Your ref: SSD 5175 MOD 2
Our ref: MC-12-1769

Section 96(2) modification request to amend the indicative concept plan, urban design guidelines and permitted uses for the Eastern Creek Business Hub

Issues for consideration – SSD 5175 MOD 2 for the 'Eastern Creek Business Hub'

Figure 2 – Location of the proposed loading dock

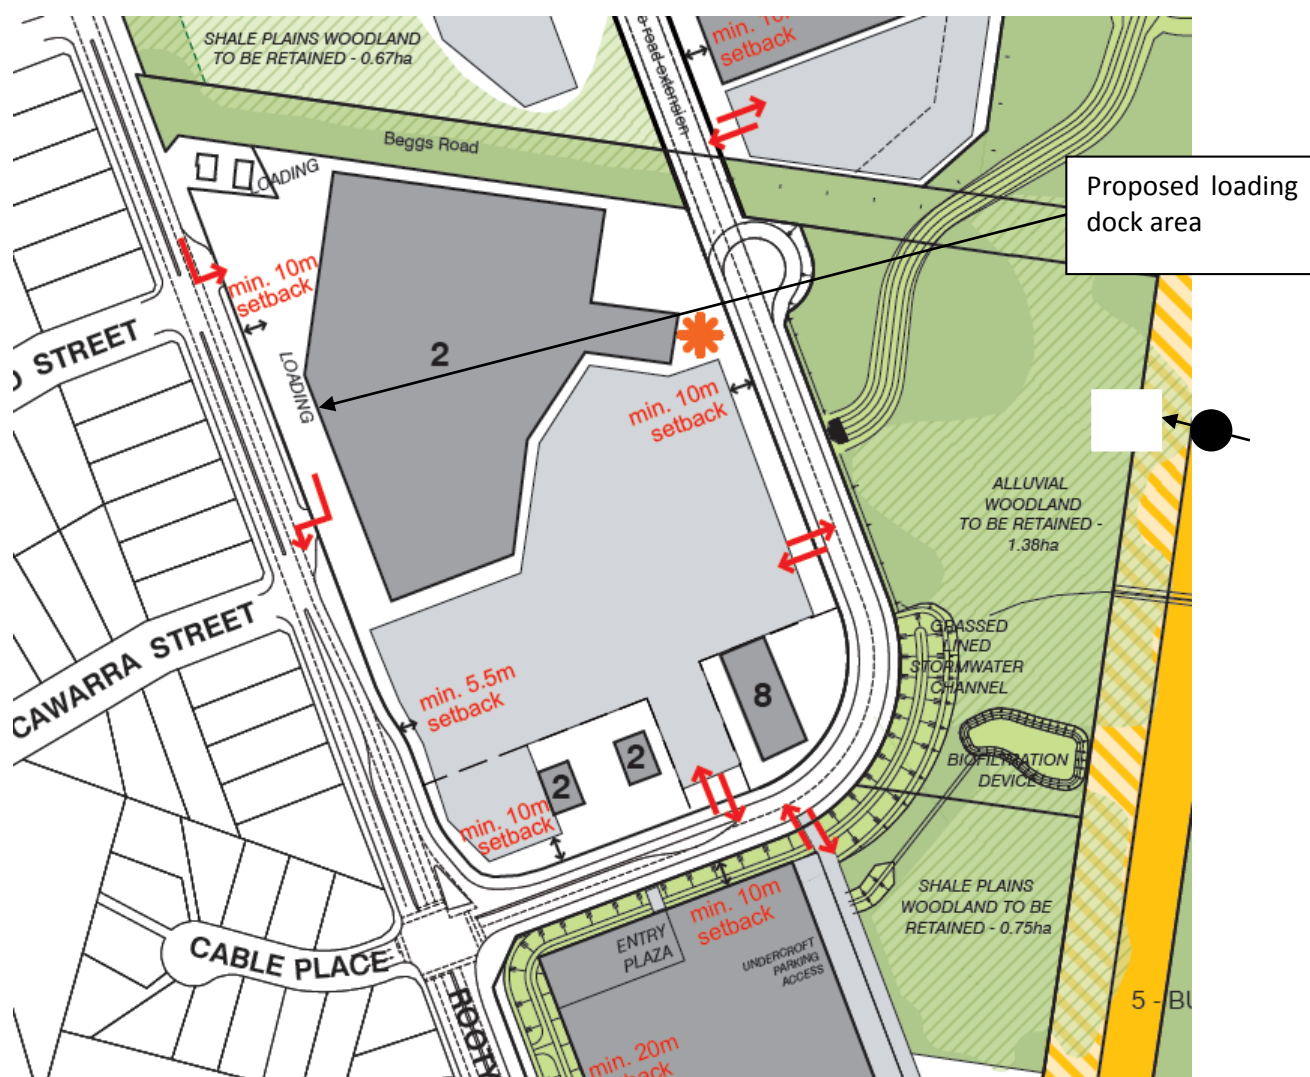
- a. We support the reorientation of the shopping centre towards the Parklands and the separation of truck and car movements. The proposed loading dock, however, is not appropriately located for the following reasons:

- It is proposed immediately adjacent to the 2 dwellings on the corner of Rooty Hill Road South and Beggs Road, and is located opposite the low density residential area on Rooty Hill Road South. The loading dock activities will therefore impact on the amenity of these nearby dwellings in terms of visual impact, noise and odour.

- While a 5 m setback has been provided to Rooty Hill Road South to accommodate screening and dense vegetation, no such allowance has been provided in the north-west corner of the site adjacent to the existing dwellings. A 5 m setback is also considered insufficient given the scale of the development and the activities proposed.

- c. To address concerns relating to potential visual, noise and odour impacts on adjacent and nearby residential properties, and concerns regarding truck access from Rooty Hill Road South (see comments below), the loading dock should be relocated adjacent to the northern boundary. The loading dock could be recessed

into the building so that a visual and acoustic barrier is provided to Rooty Hill Road South and to the new internal access road. All truck access could be provided via a separate driveway off the internal access road.

Figure 4 Proposed Concept Plan

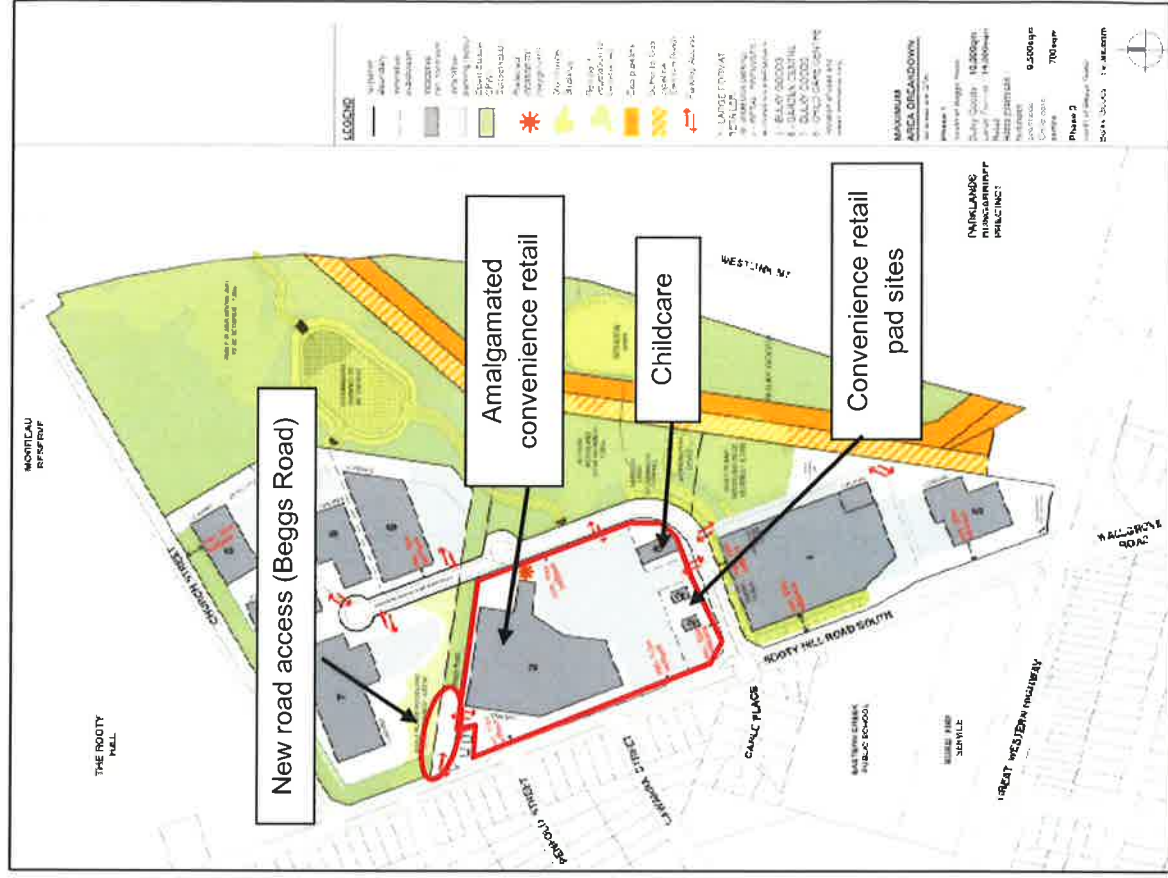
- We disagree that the visual impact of the loading dock will be minimal. Figure 4 on page 7 of JBA's section 96(2) report indicates that the level change between Rooty Hill Road South and the loading dock will be less than 2 m. At the south-west corner of the building the level change is less than 1 m. Therefore the 'back' of the building (i.e. roller doors, waste storage area, trucks, etc.) and loading dock activities will be highly visible from Rooty Hill Road South.

Figure 25: Preferred Indicative Layout

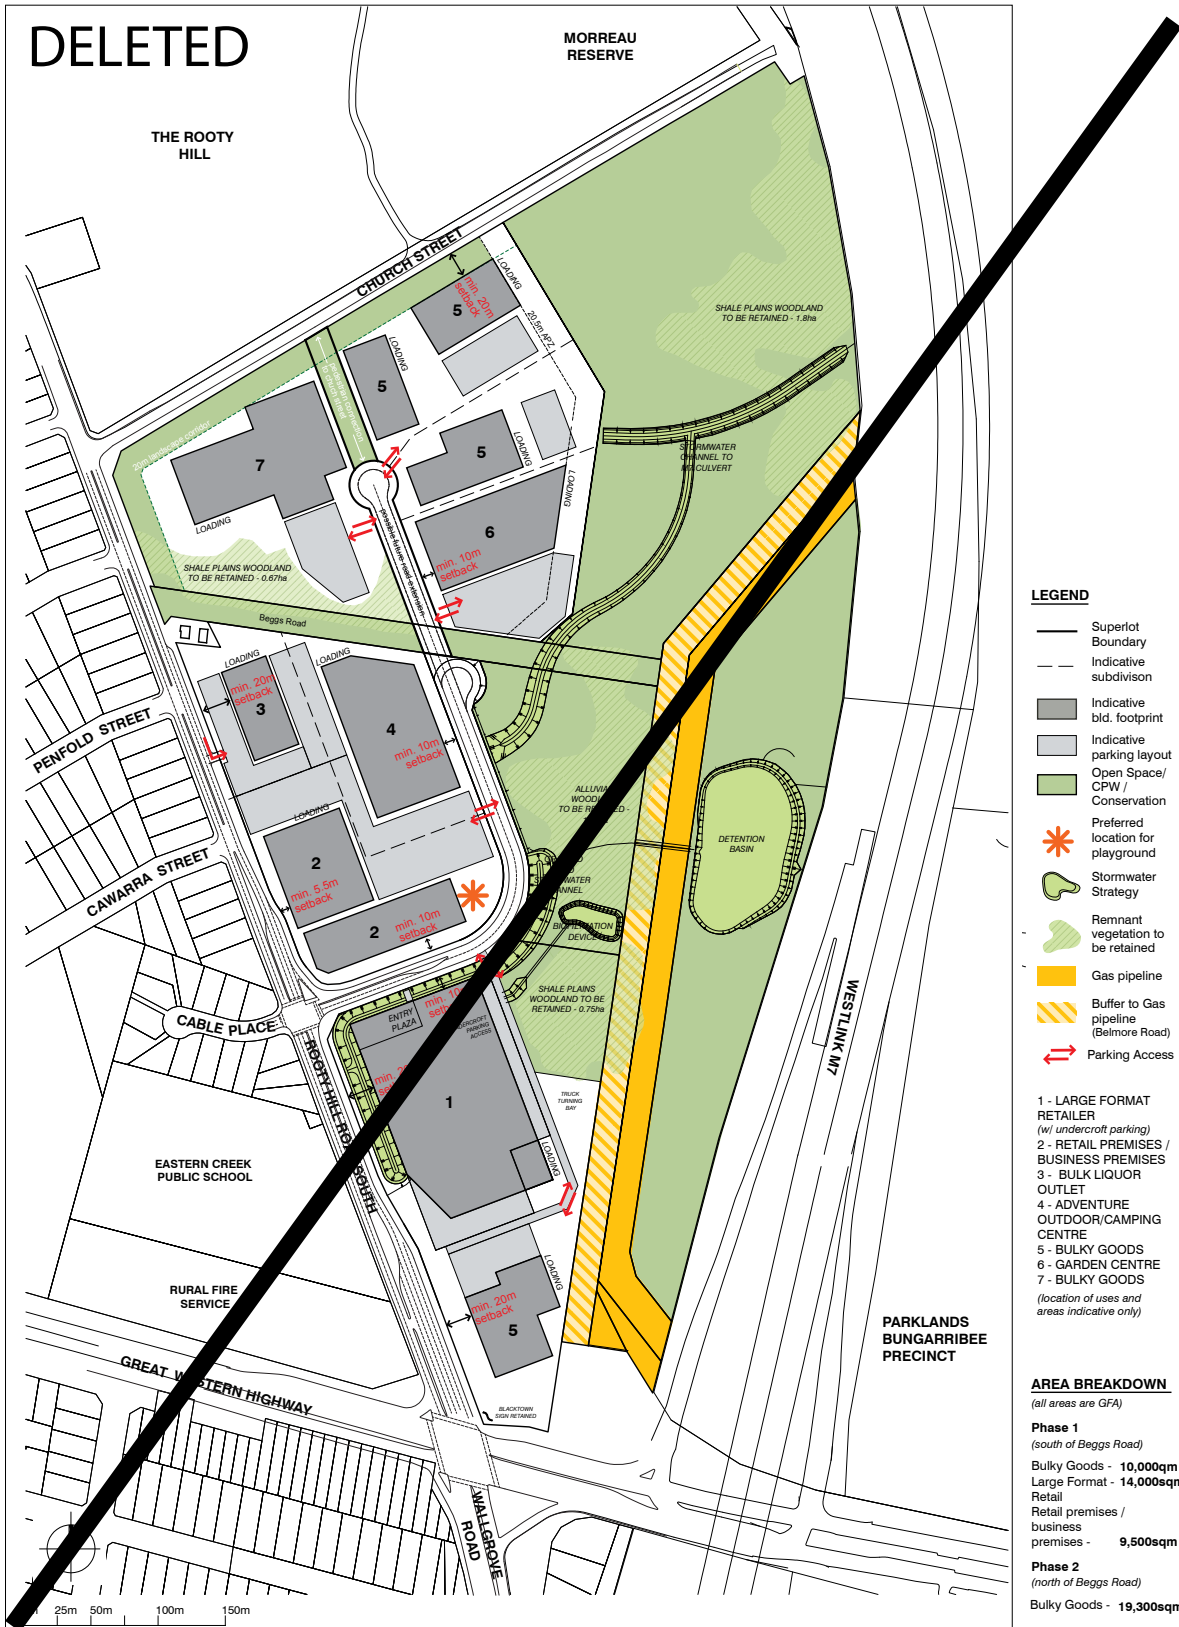
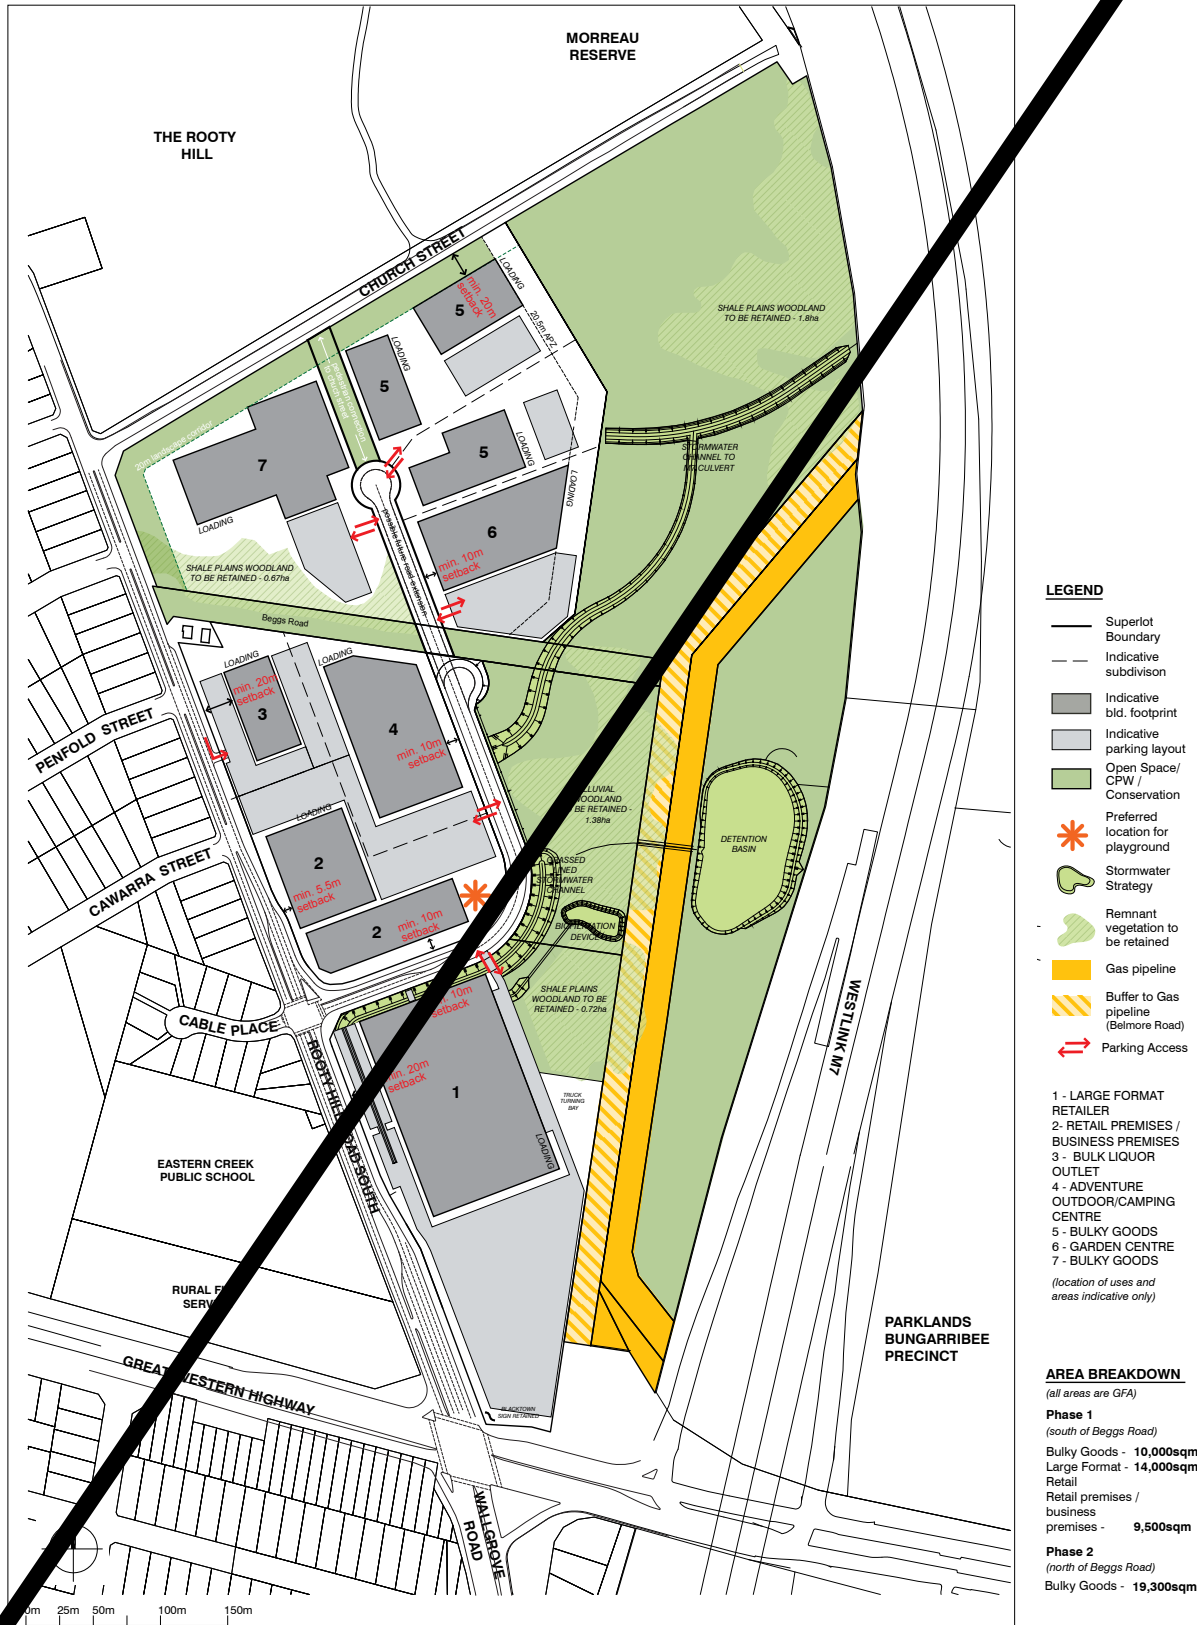
- The document should be updated to make reference to figure 25 on page **17 27.**

Figure 30: Indicative Lot Subdivision Option 1

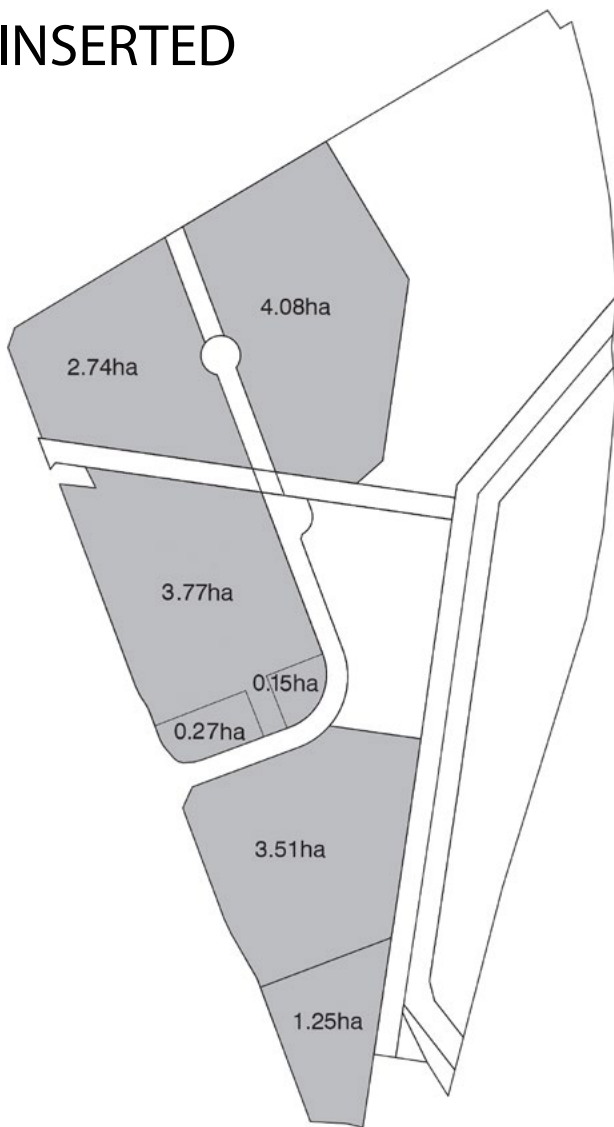
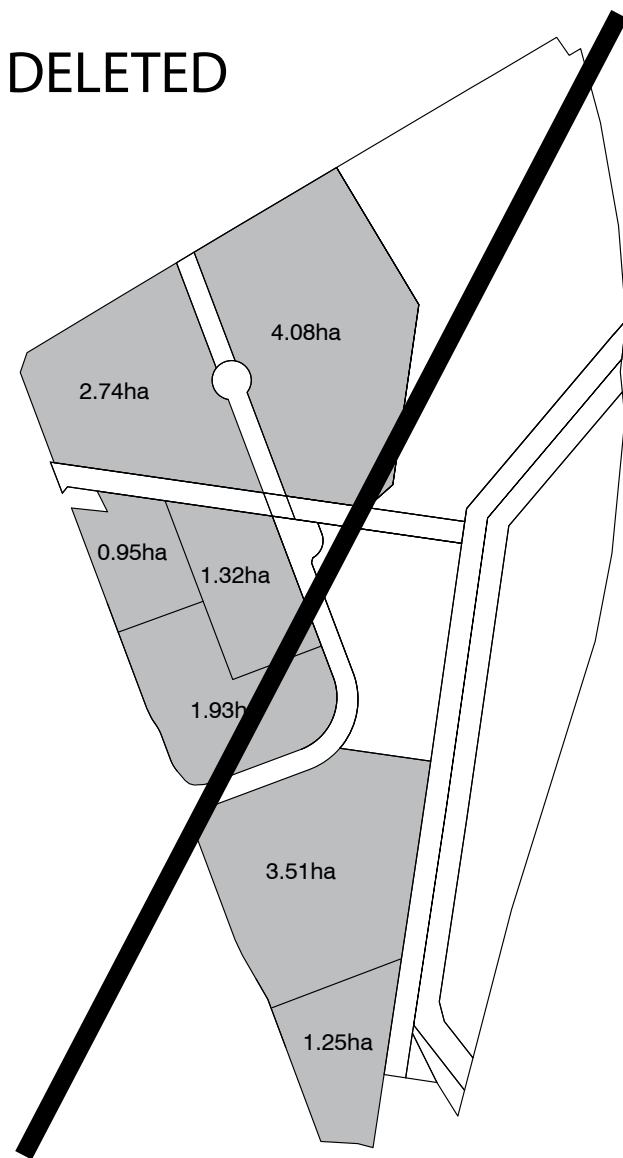
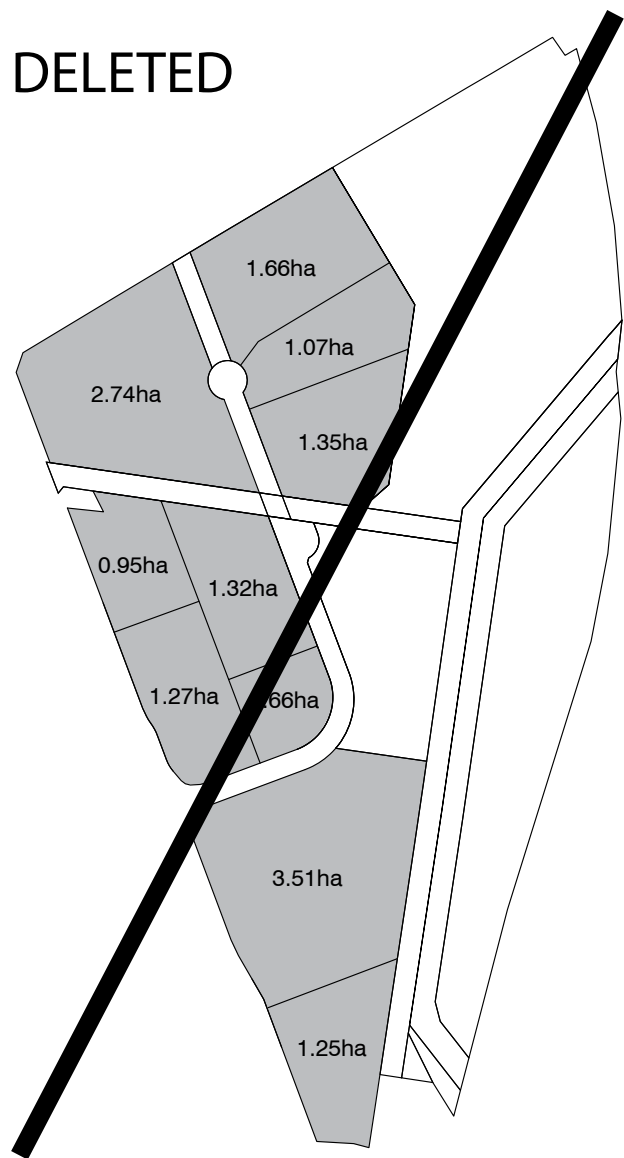
- References to the minimum lot sizes have been deleted. These should be reinstated with the minimum lot sizes being consistent with those shown in figures 30 and 31.
